# Letter of Transmittal

Re: Forest Ridge

RE: Creekside Road and Forest Ridge Drive Phase 2 Grading Permit County Comments

Attached to this letter is a response to review comments from a letter received from the County dated May 21, 2021 concerning the Forest Ridge Development (Phase 2). Our responses are listed below in the order provided.

CONFIRMATION THAT SWALES CAN HANDLE DESIGN FLOWS

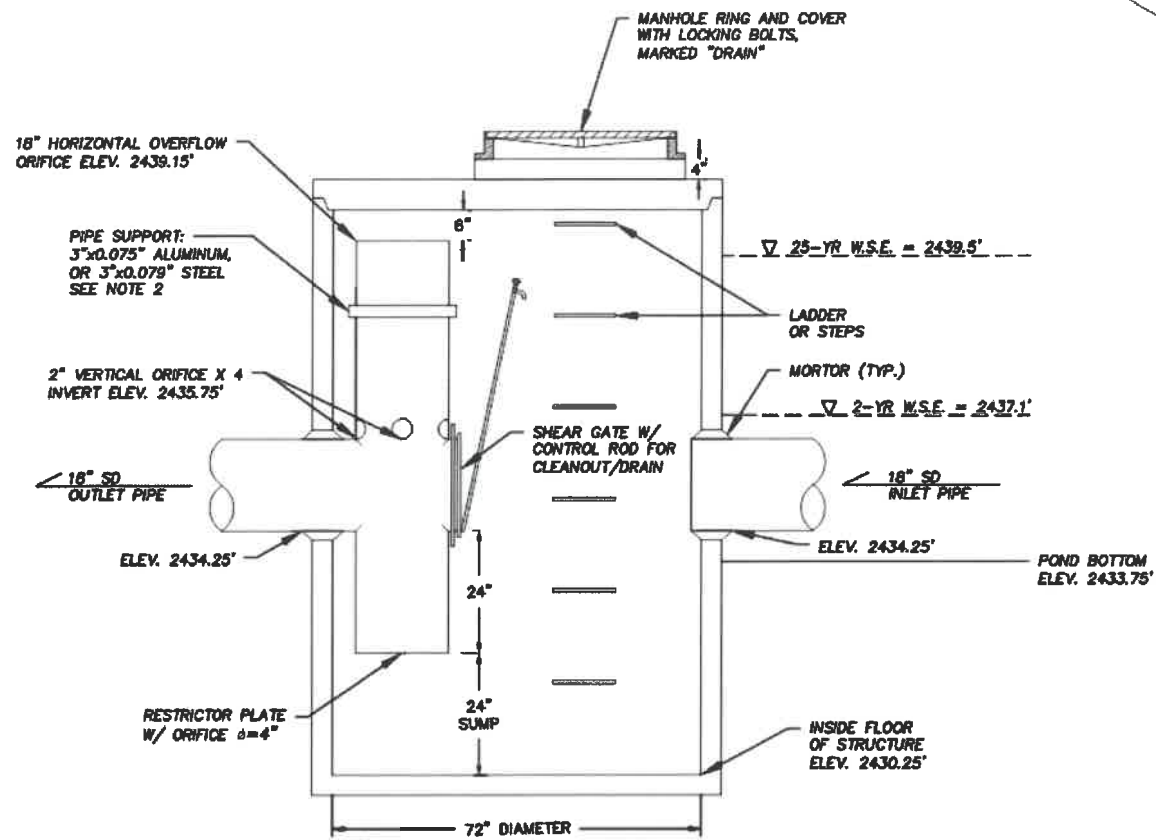
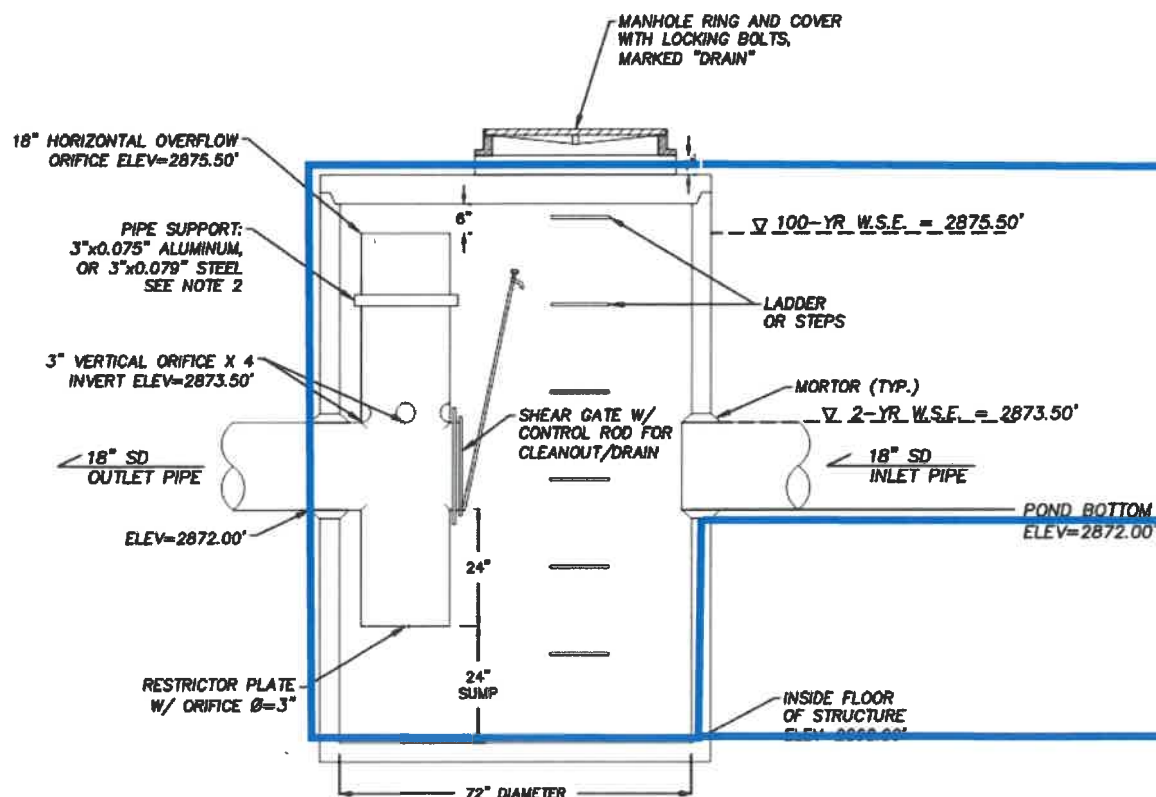
4. See attached exhibit.
5. See attached exhibit.
6. See attached exhibit for capacity of swales.
  - a. In terms of the Bubble Up Dispersion Trench, it is not meant to control flows. That is what the pond is for. The trench just disperses the runoff it receives from the pond. Since the pond has an outlet structure designed to release runoff per the SWMMEW, the trench will release runoff at the same rate it receives it (although slightly delayed).
